Job No. 188050

March 18, 2022
Amended January 10, 2023

Comments have been provided on
Figure 2 map sheet.

Re: Wastewater Study
Mountain Rd
Guntzelman Porcelain Pines Subdivision
El Paso County, Colorado

**PROPOSED LOT
LAYOUT**

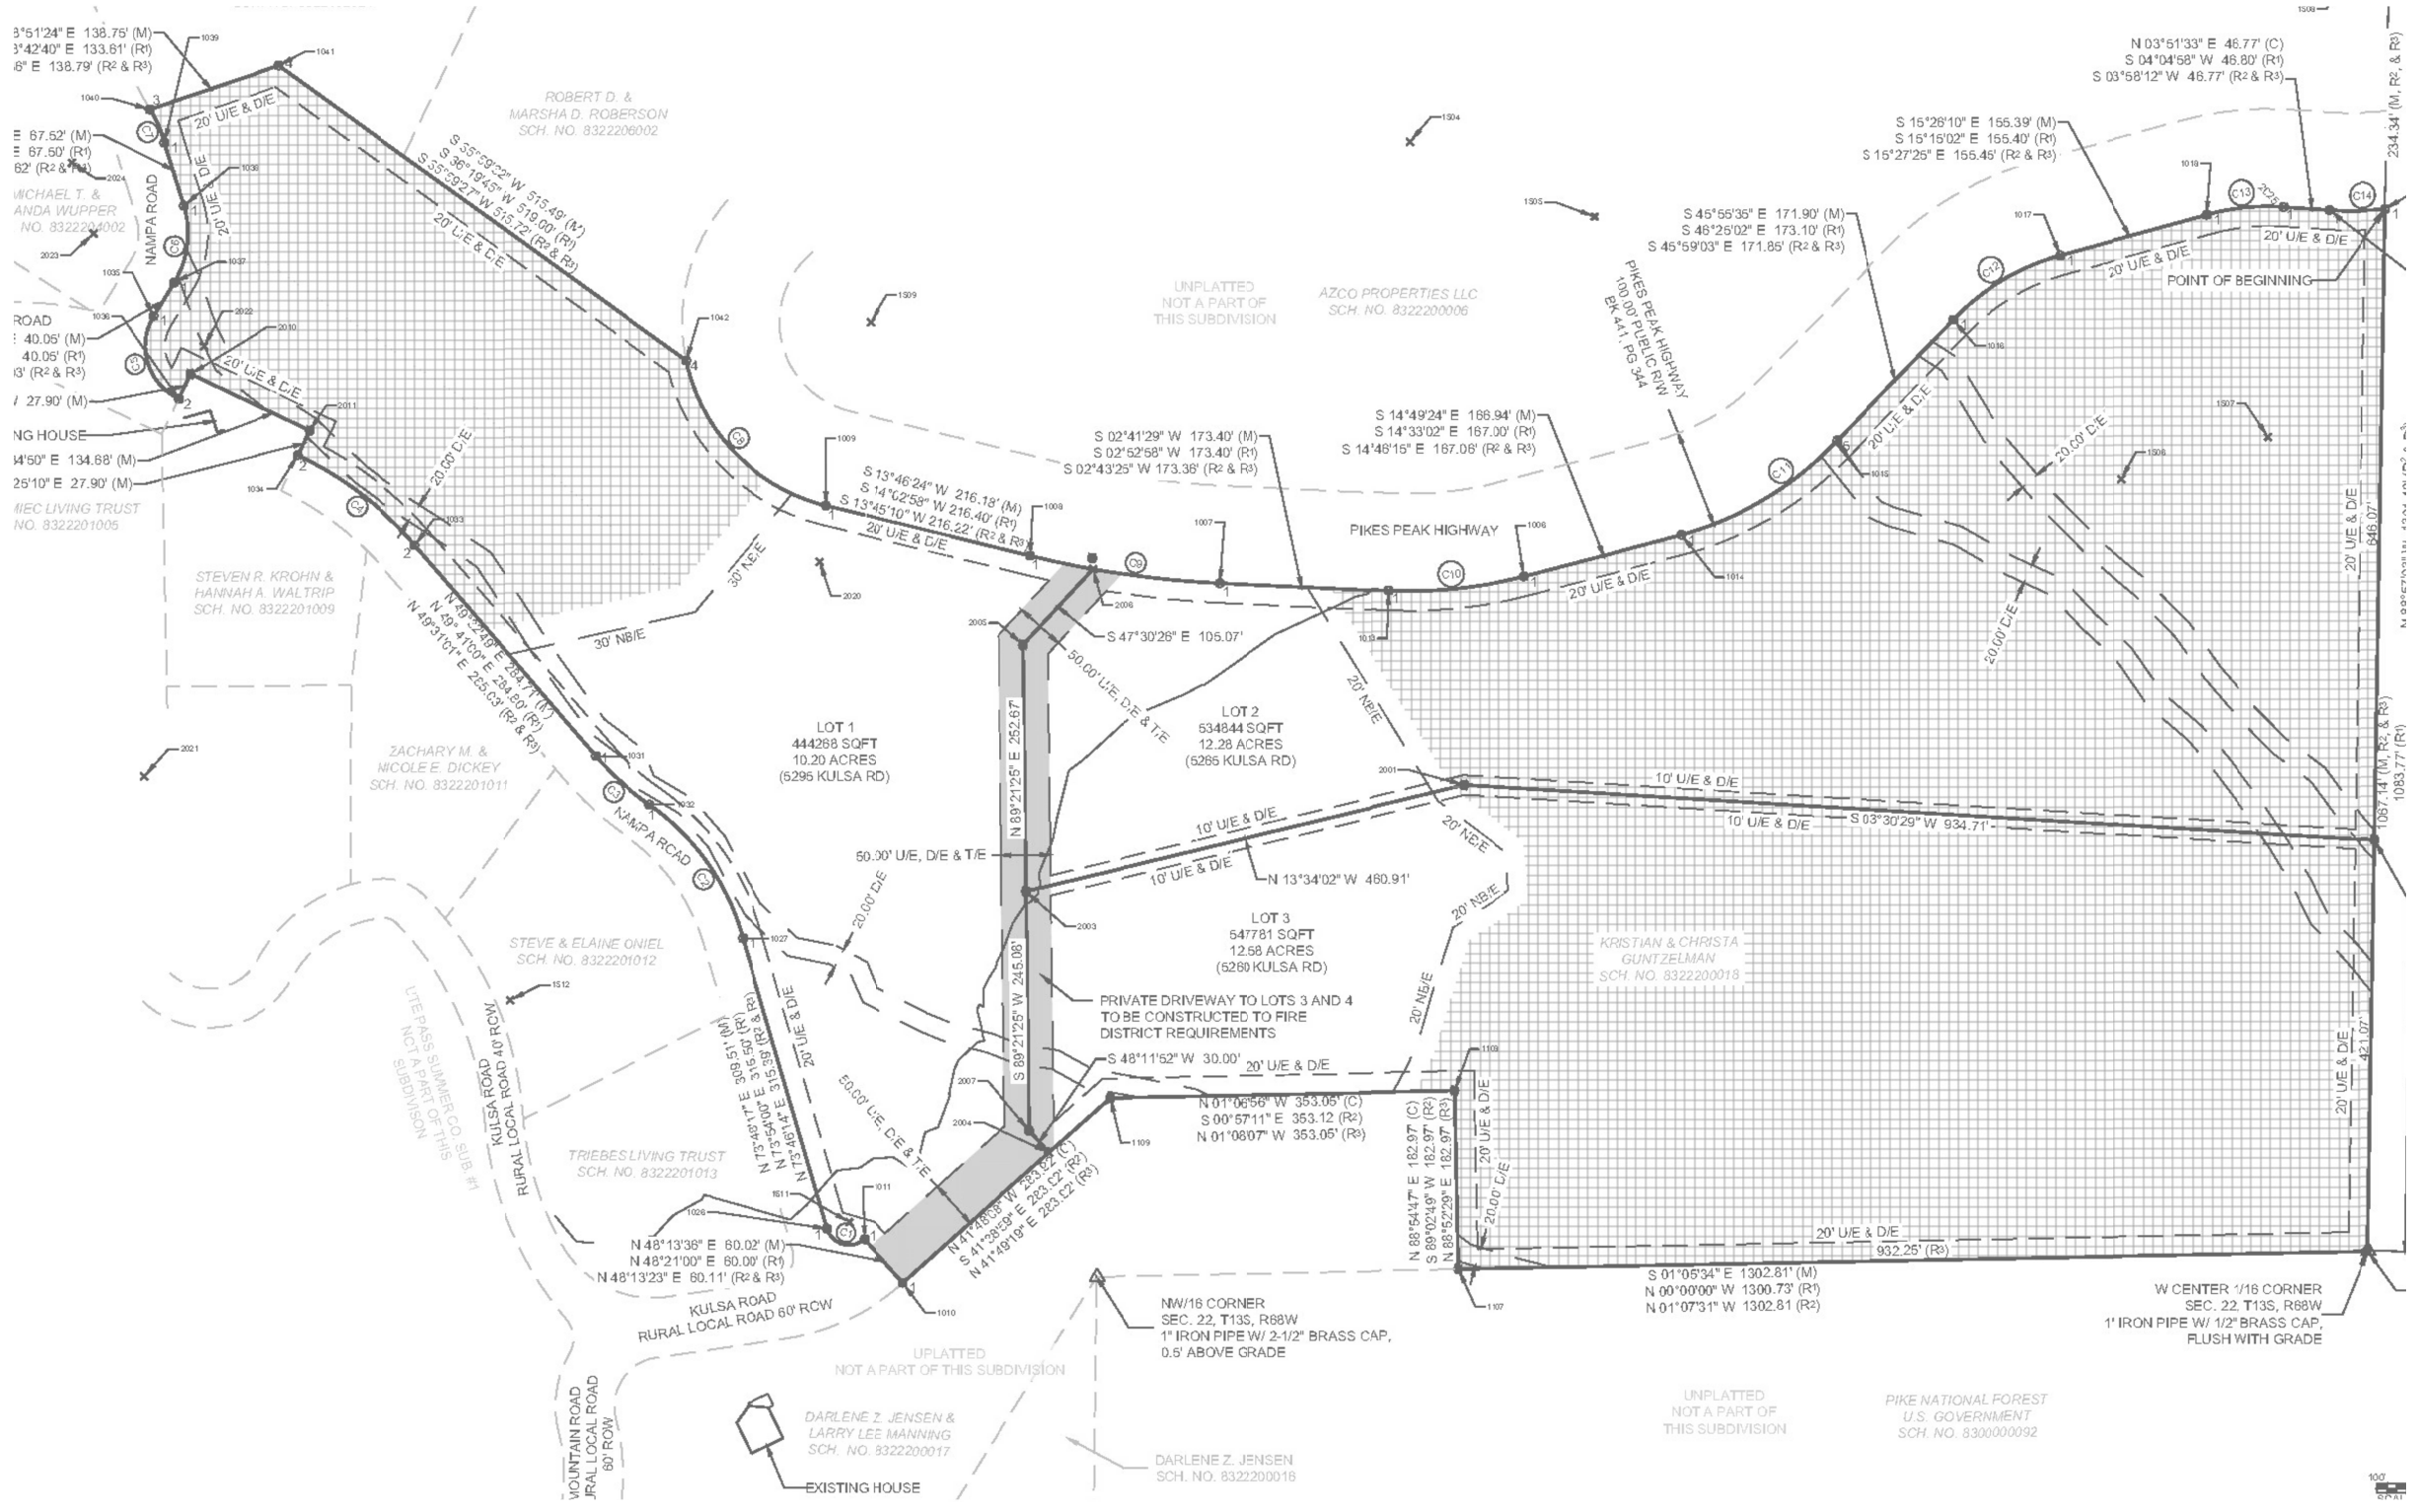
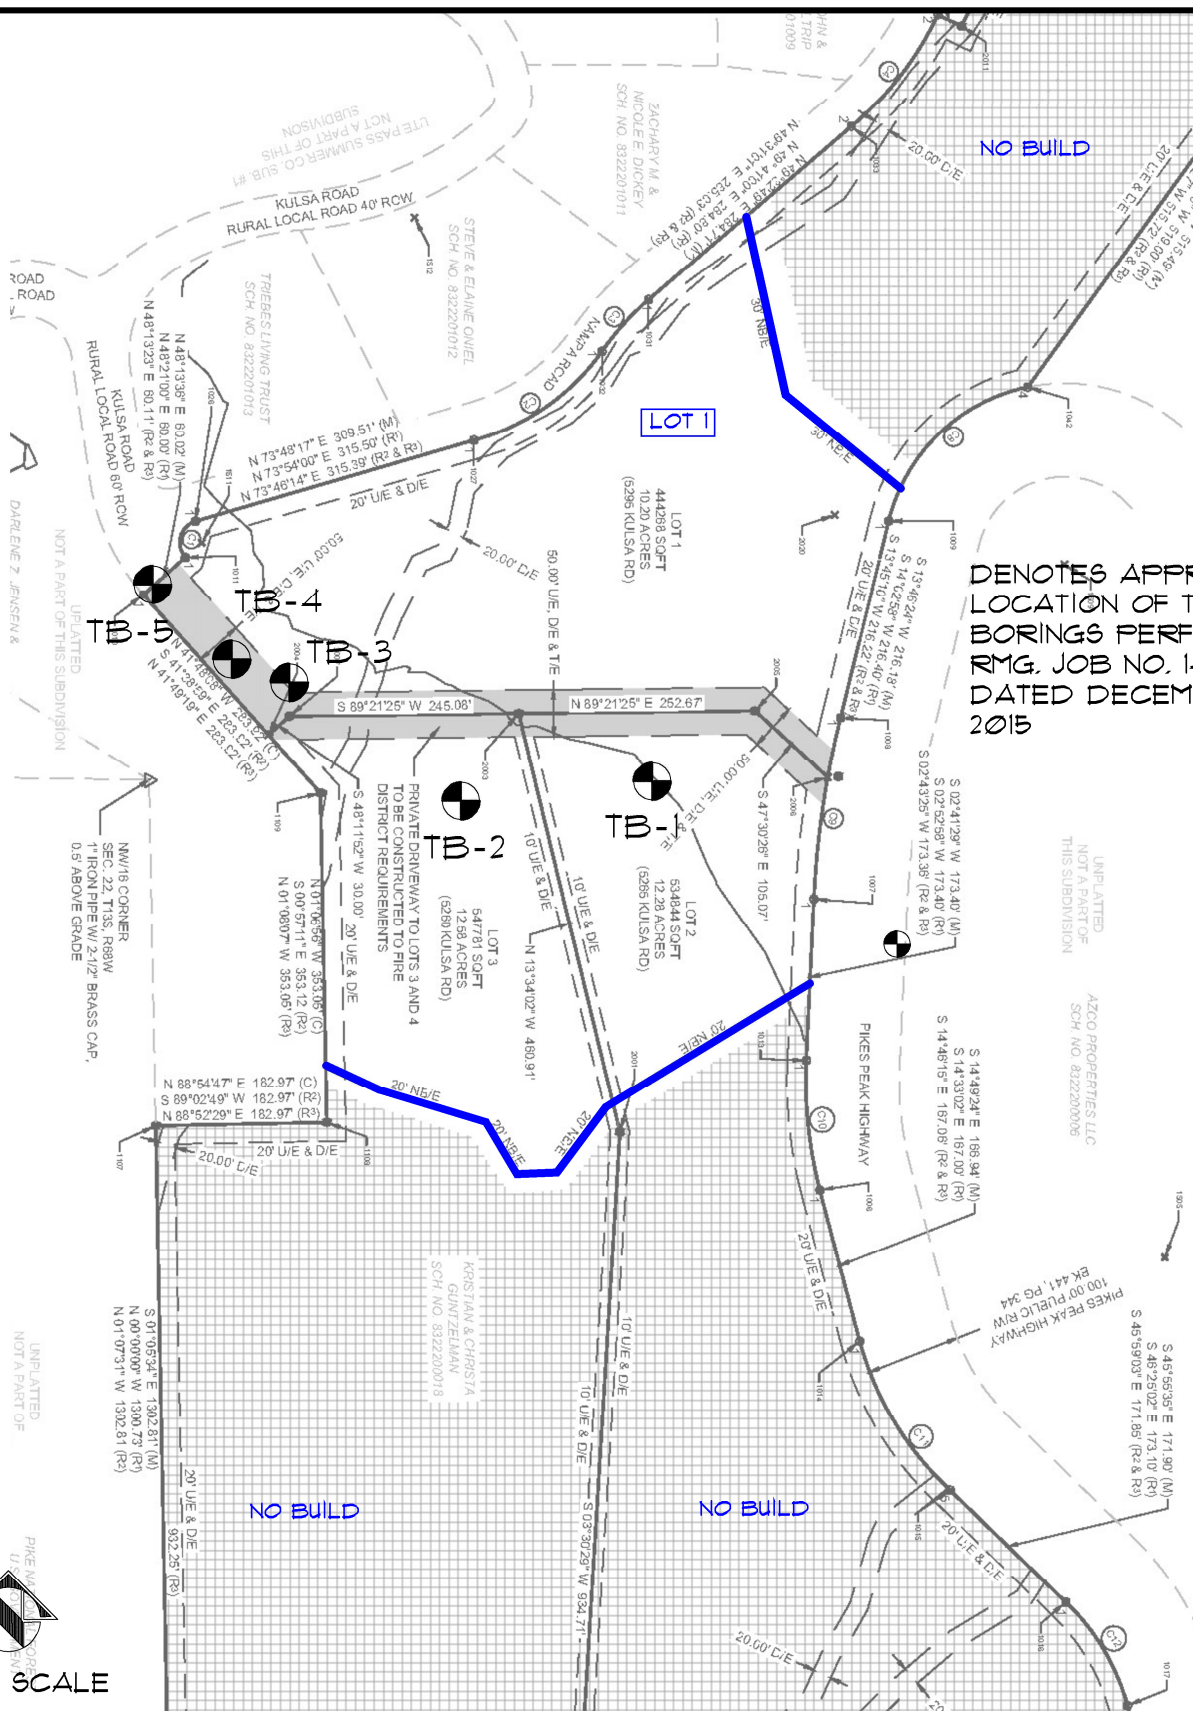
I am a little confused by this exhibit - lots 2, 3, and 4 show four septic locations each and lot 1 shows zero septic locations. This exhibit should also depict the geologic hazards and constraints.

FIG No. 2

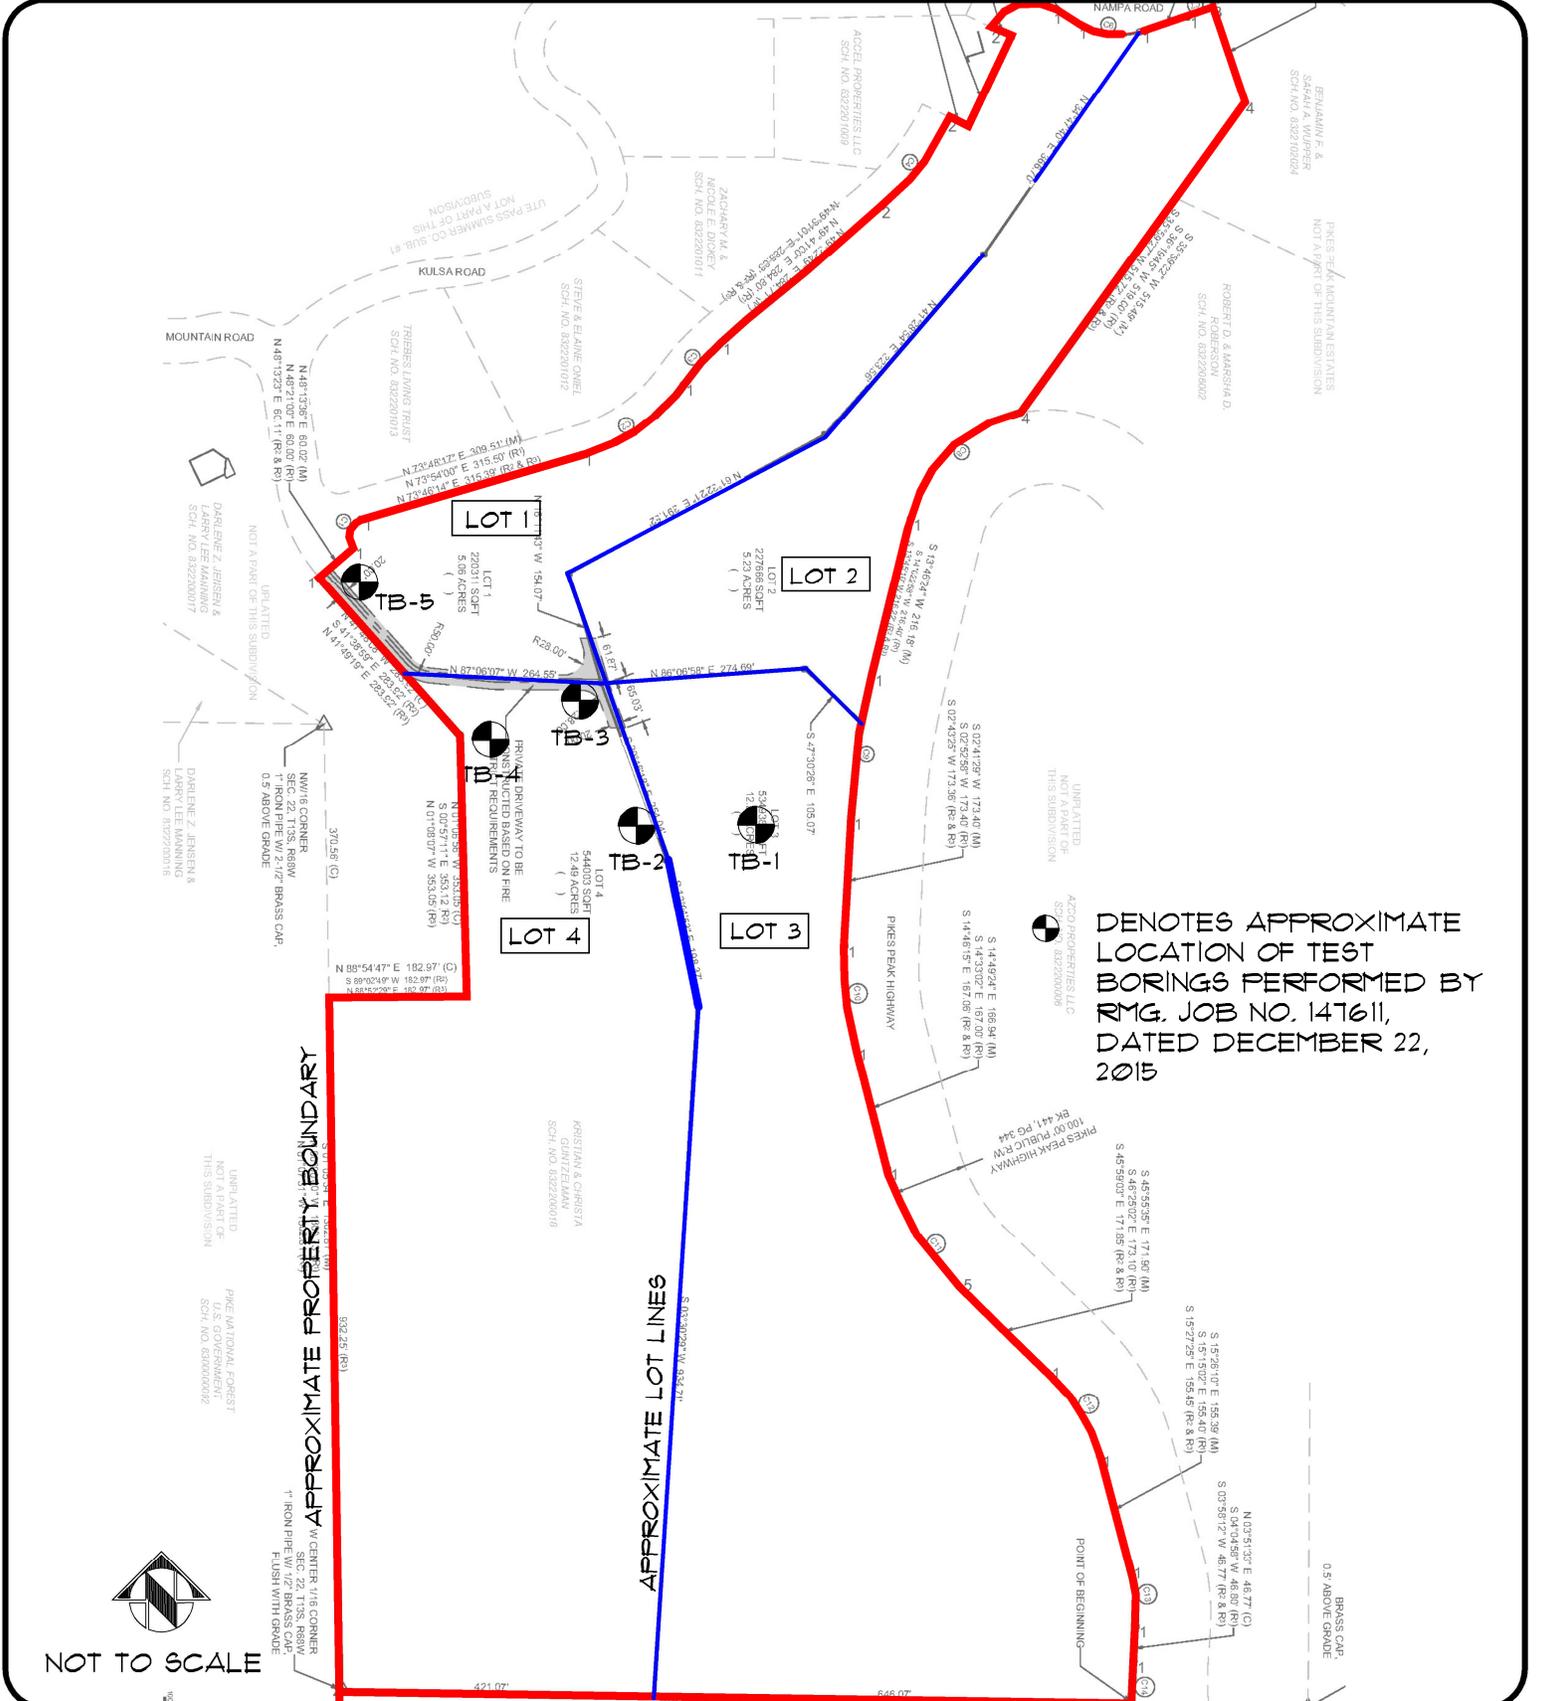
Soils and geology report denotes this area as having steep slopes. How will this be acceptable locations for septic?
